From: [REDACTED]
Sent: 04 March 2021 12:53
To: Planning
Subject: Fwd: Re: Request for further information - AB/19/21/HH - incorrect Application description

project: 32 Maltravers Street - Arundel - BN18 9BU			
drawing title: Existing & Proposed Ground Floor Plans			
drawing status: Planning Application Proposals			
date: 01 - 03 - 2021	scale at A3 original size 1:100	no: JW2012ARU - PL04	rev: E

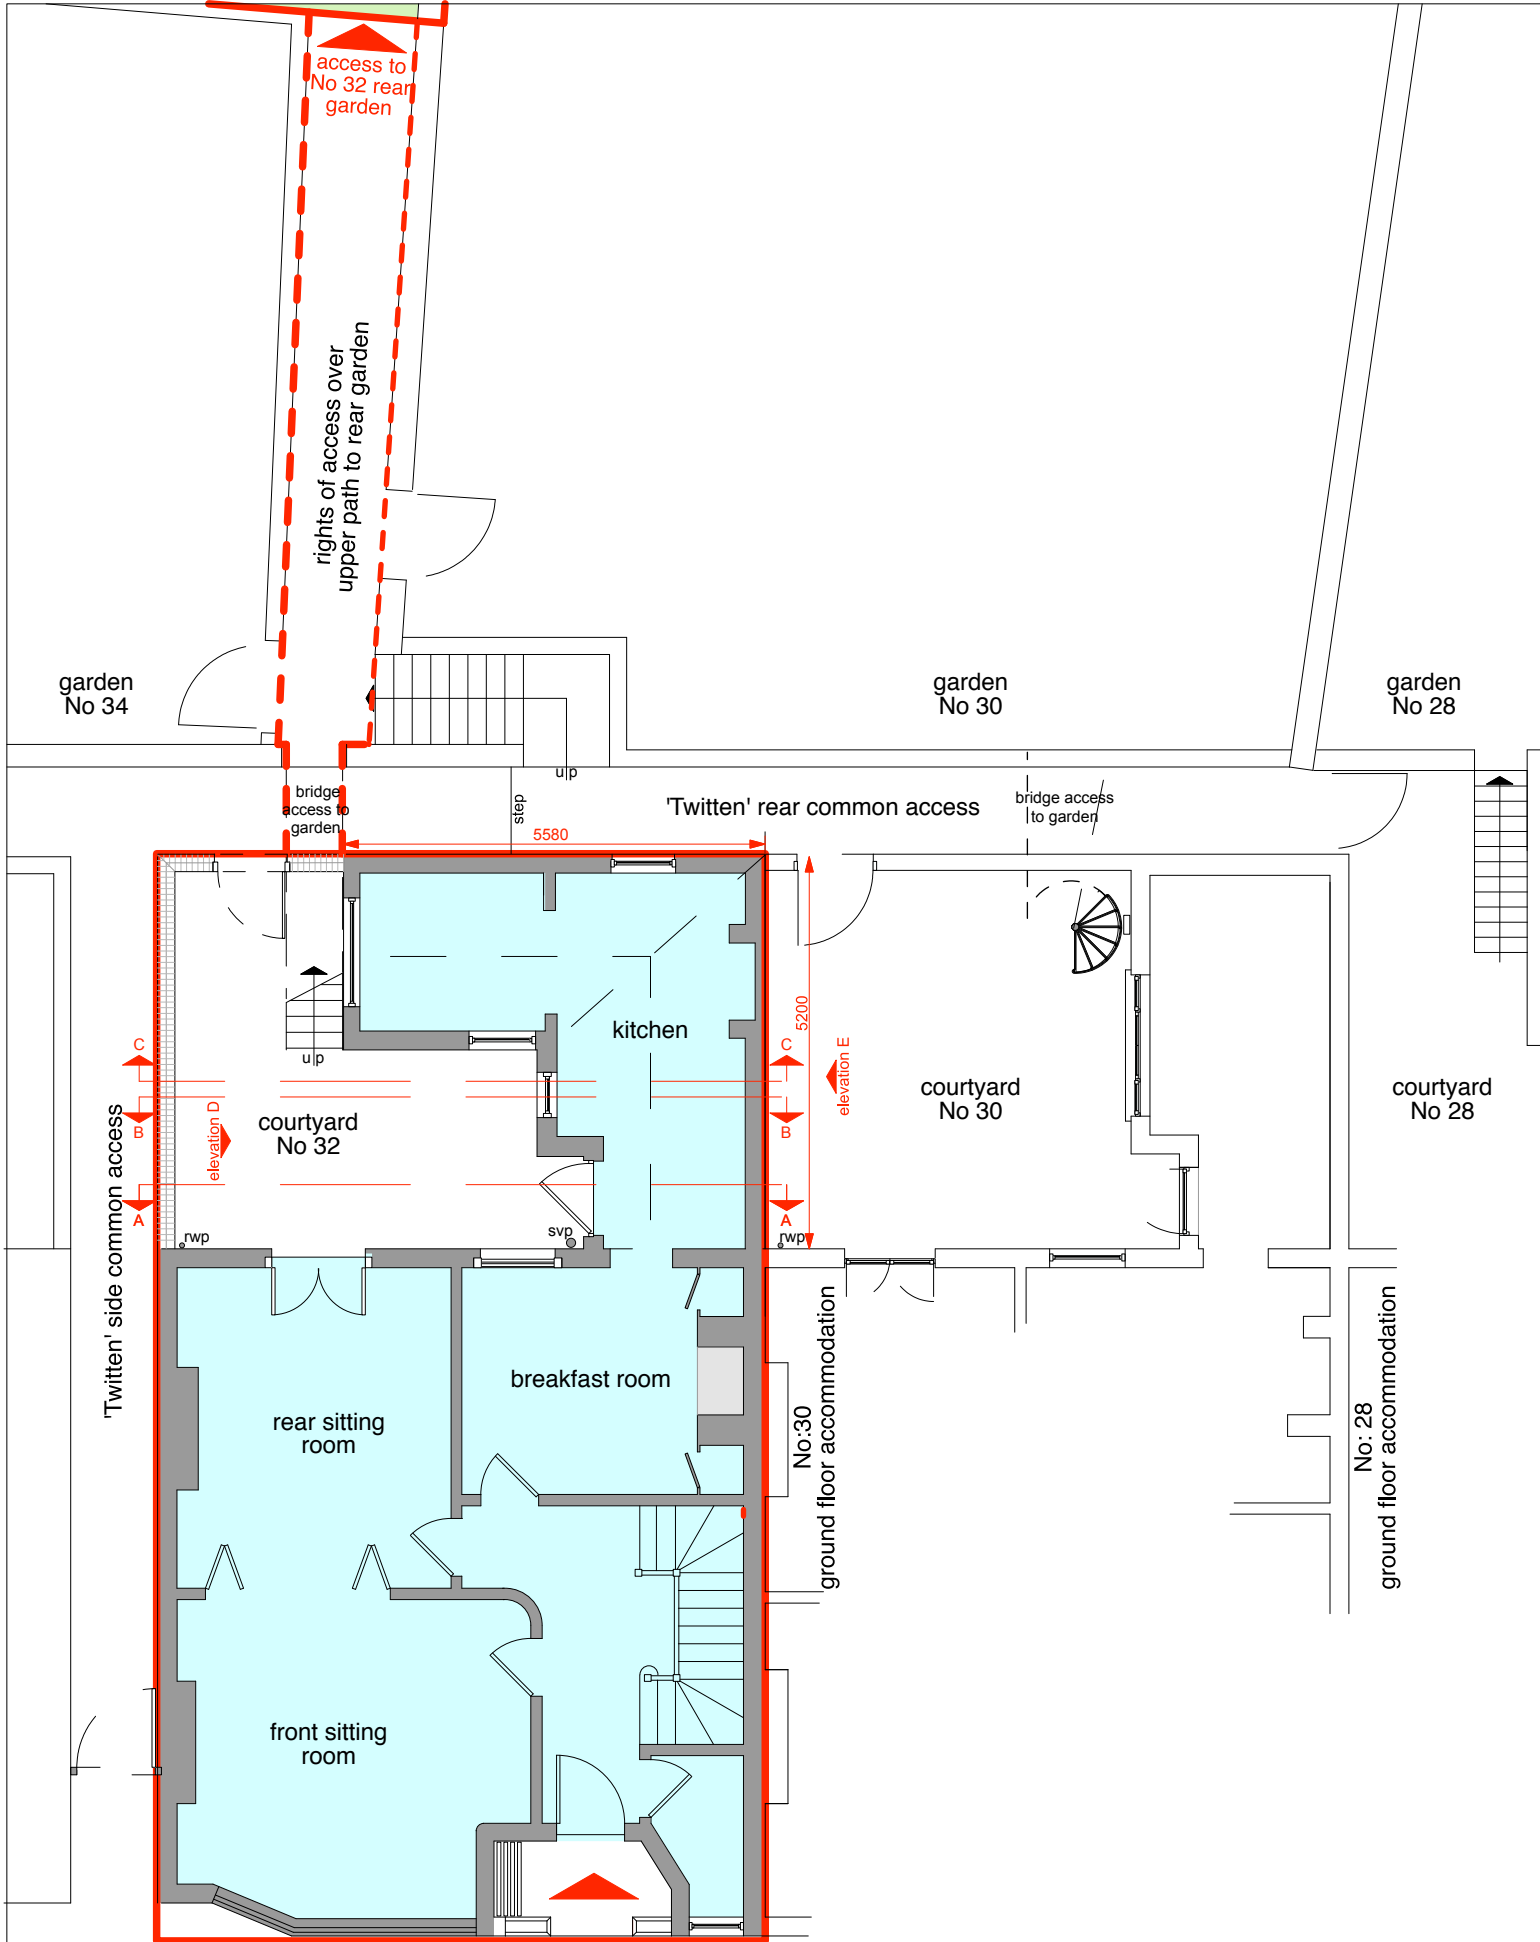
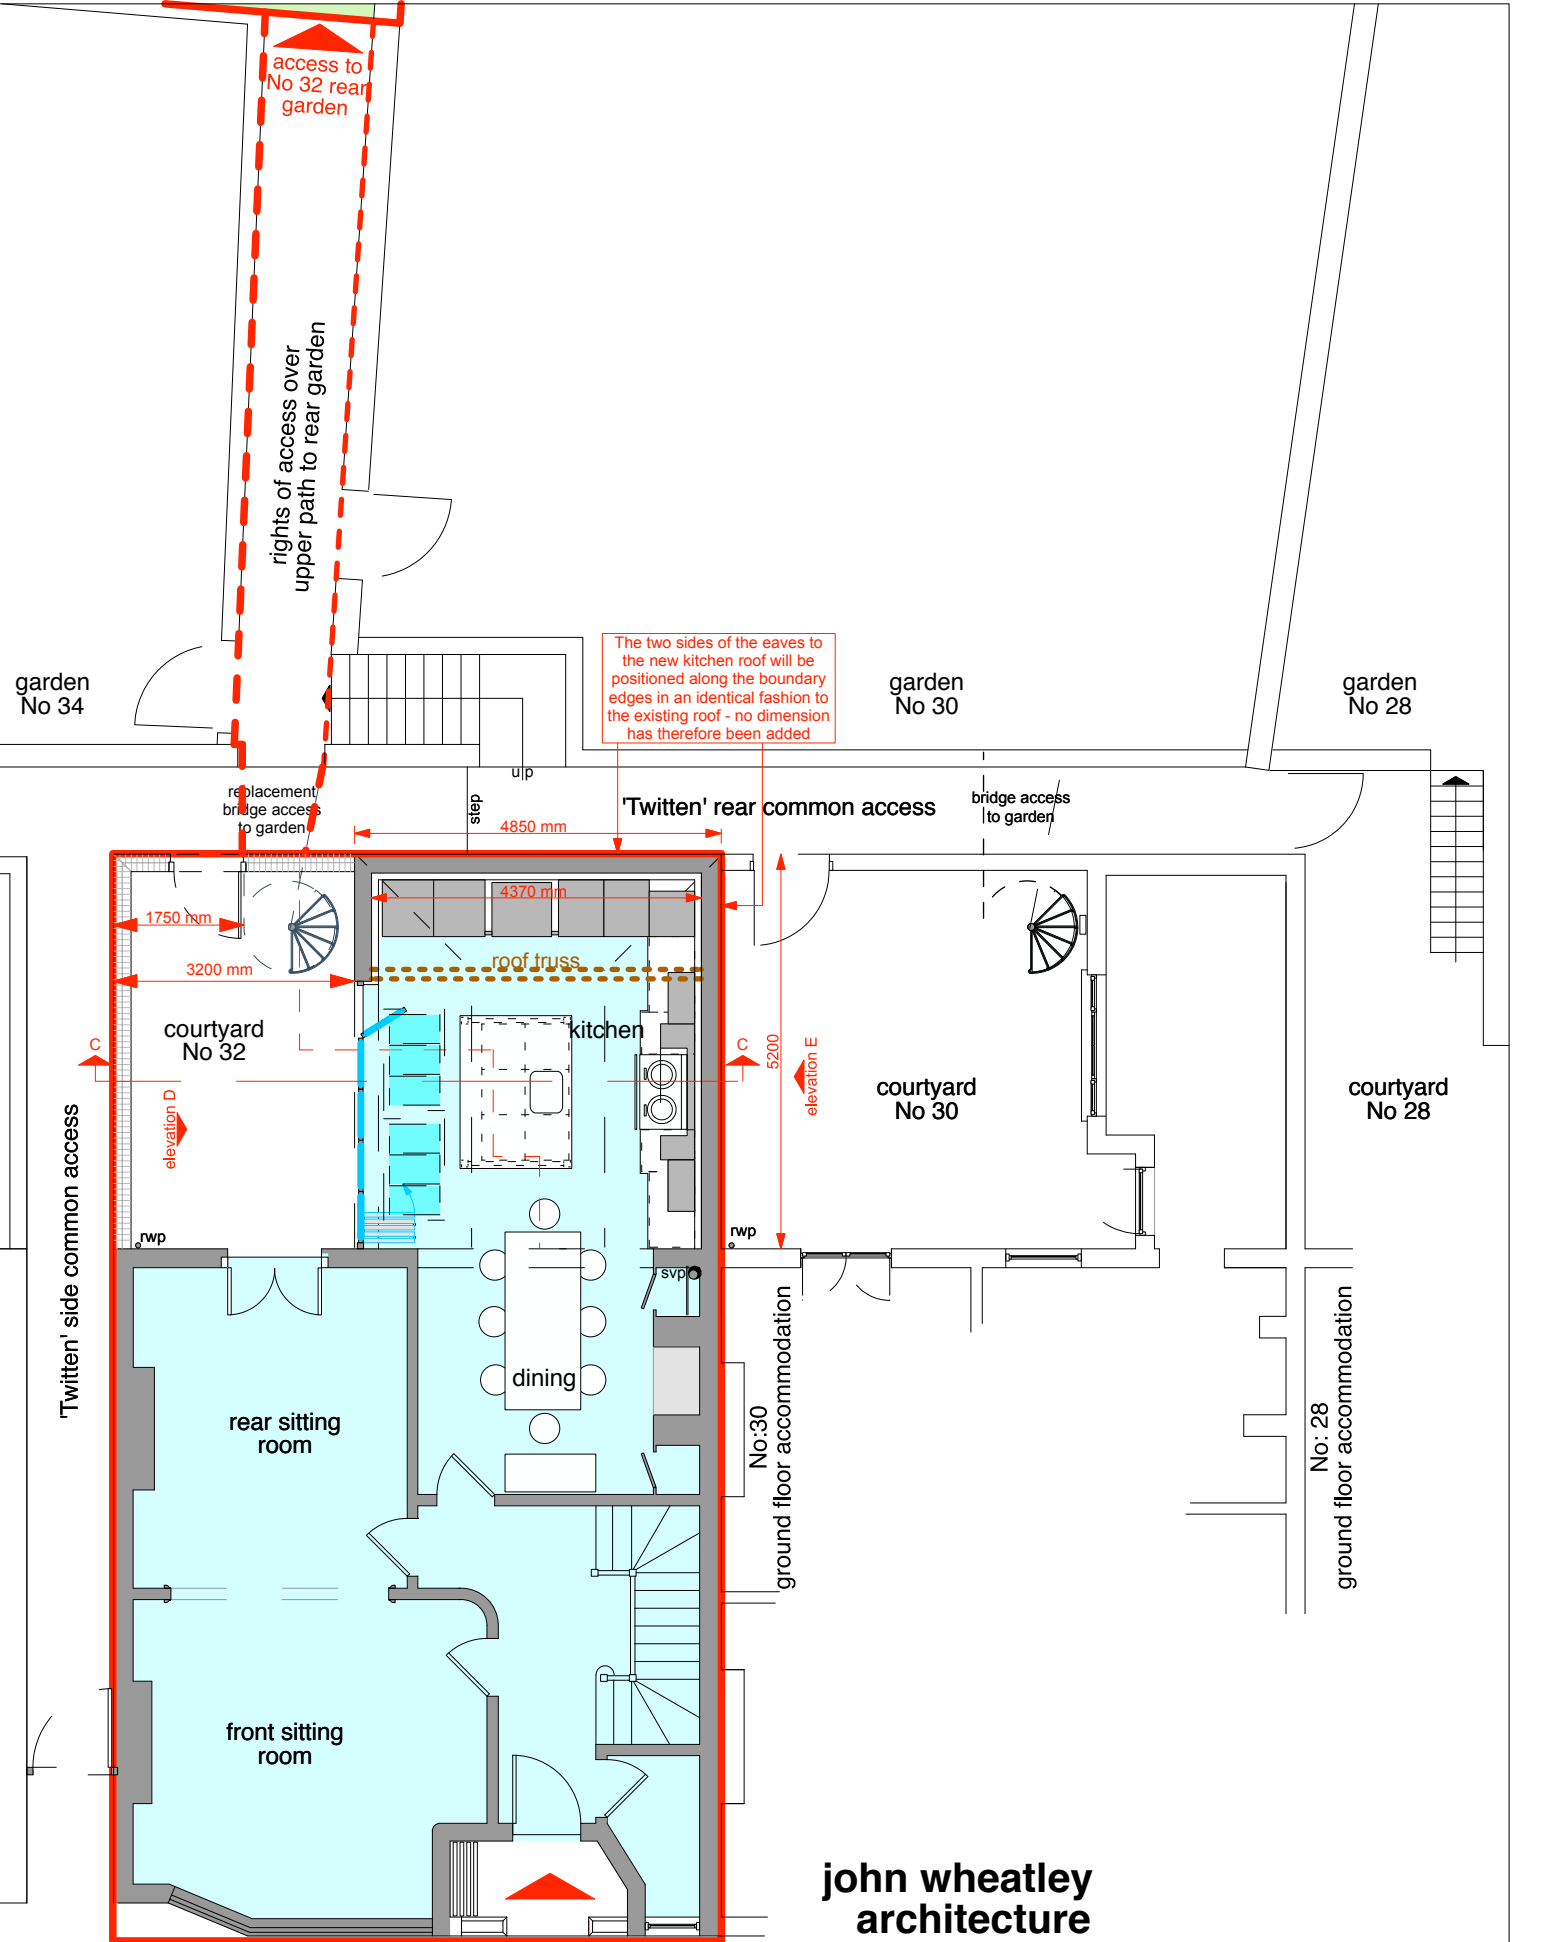
- **Dimensions:** You are required to include dimensions from the proposed extensions to all site boundaries. Apologies for this omission - I have now added dimensions to the courtyard on the Proposed Ground Floor Plan on a now later revision of PL04.

PL04 Rev E - also including the additional dimensions, issued prior to being added to the Block Plan, and clearer on a 1 to 100 scale drawing than 1 to 500.

**Development at 32 Maltravers Street Arundel BN18 9BU
PL01B - Location Plan at 1:1250 scale (A4)**

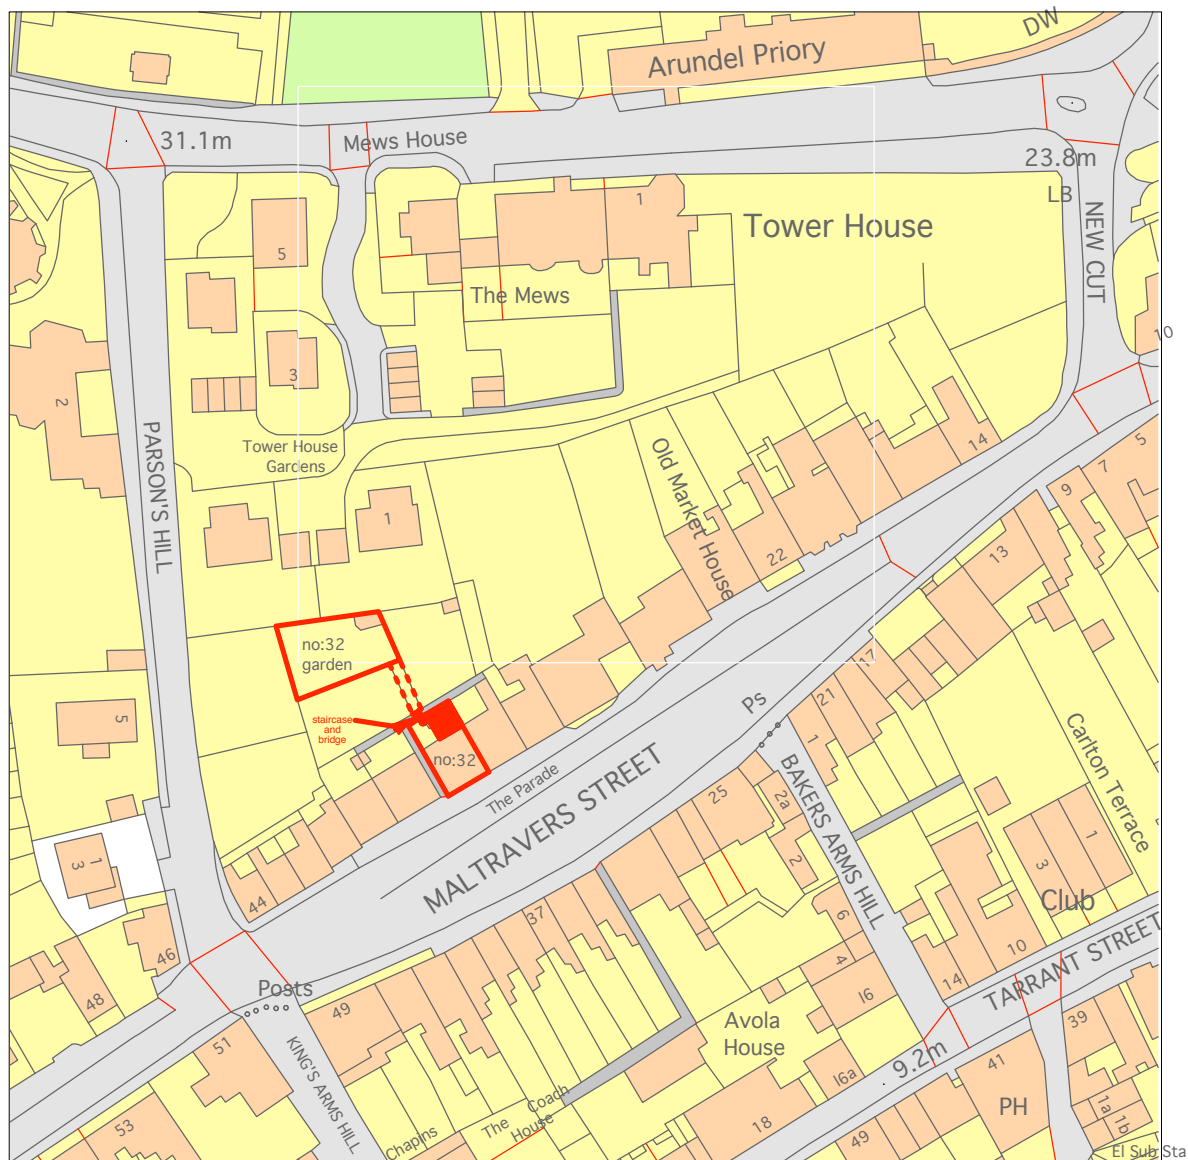
- **Location Plan:** You are required to only include the proposed site in the red outline on the location plan. Please remove all other red outlines. I was aware that the red line boundary has to be added to the Location Plan, but thought that inclusion on other plans was optional. I typically keep the red lines on all boundaries, so that the context is maintained between different scale plans and have not removed this information therefore as yet. If however you feel it is not possible to register the plans without the redline being removed on PL02, PL03 and PL04, I will reissue them immediately.

I am confused how this has happened, but I will check the printing of pdf copies and re issue all six drawings. However I would just point out that I will be re issuing the Location Plan PL01 Rev A as an A4 drawing (not A3) at a 1 to 1250 scale. This will be the only drawing that is not A3 in paper size. I will be retaining the same revision numbers since the contents of the drawings will not change. These revisions should be as follows, following our recent correspondence.
